Sent: 12 October 2012 09:26
To: Planning
Subject: Planning application N6/2012/1913/AD - 1 Howardsgate

Response to Planning application from Hertfordshire County Council (T and CP GDP Order 1995)

Location
1 Howardsgate
Welwyn Garden City

Proposal
Installation of low voltage external fascia and projecting signs

Signage Section A 1:10

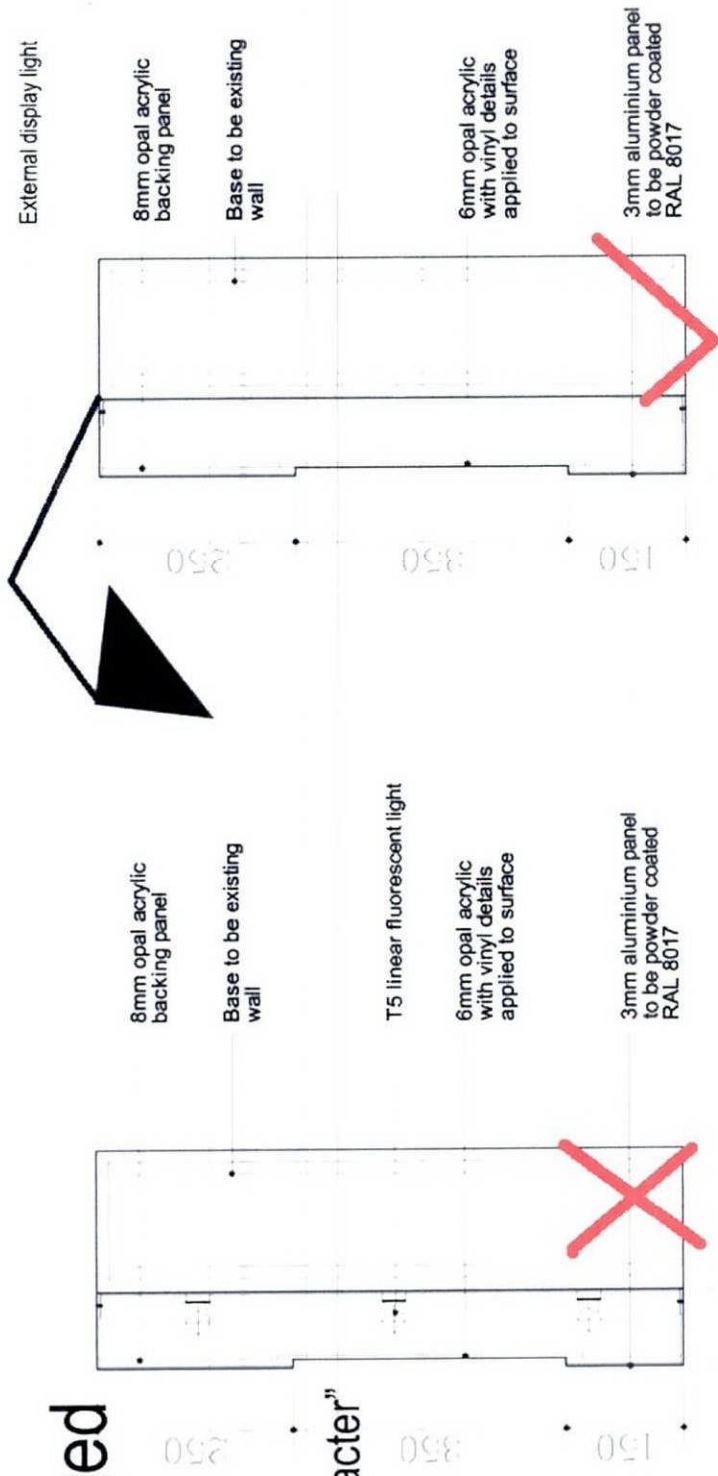
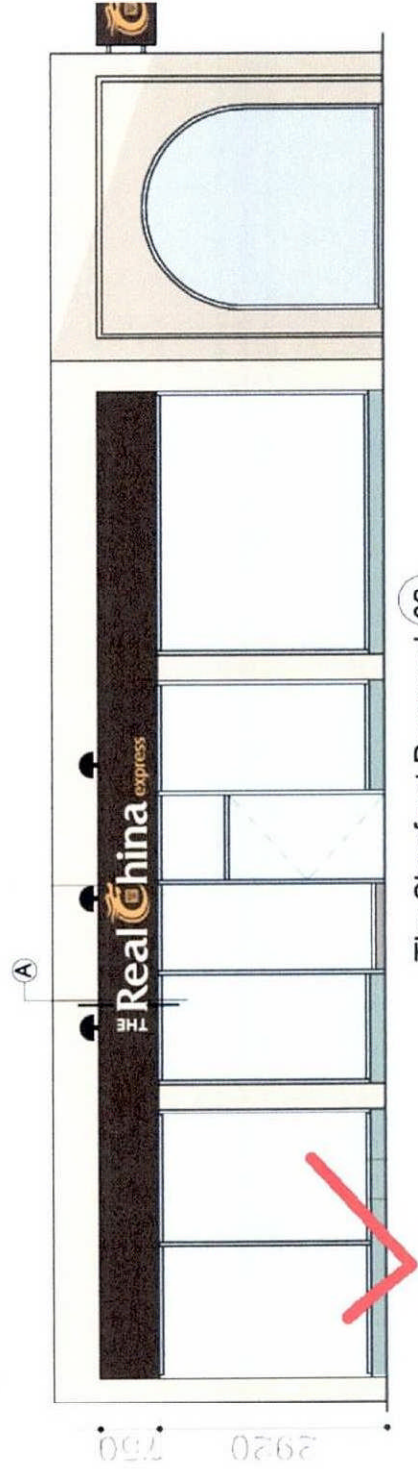
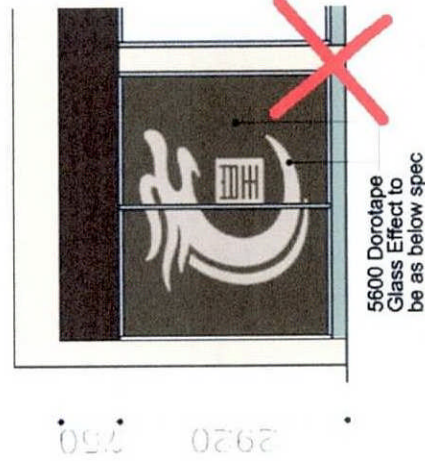
COMMENTS: The proposed signage as shown on drawing number E-0-02 has no implication on highway safety and conditioned as above would not affect the free passage of pedestrians.

The intensity of illumination shall be controlled at a level that is within the limit recommended by the Institution of Lighting Engineers in the publication "Brightness of illuminated Advertisements" ILE Technical Report No 5.
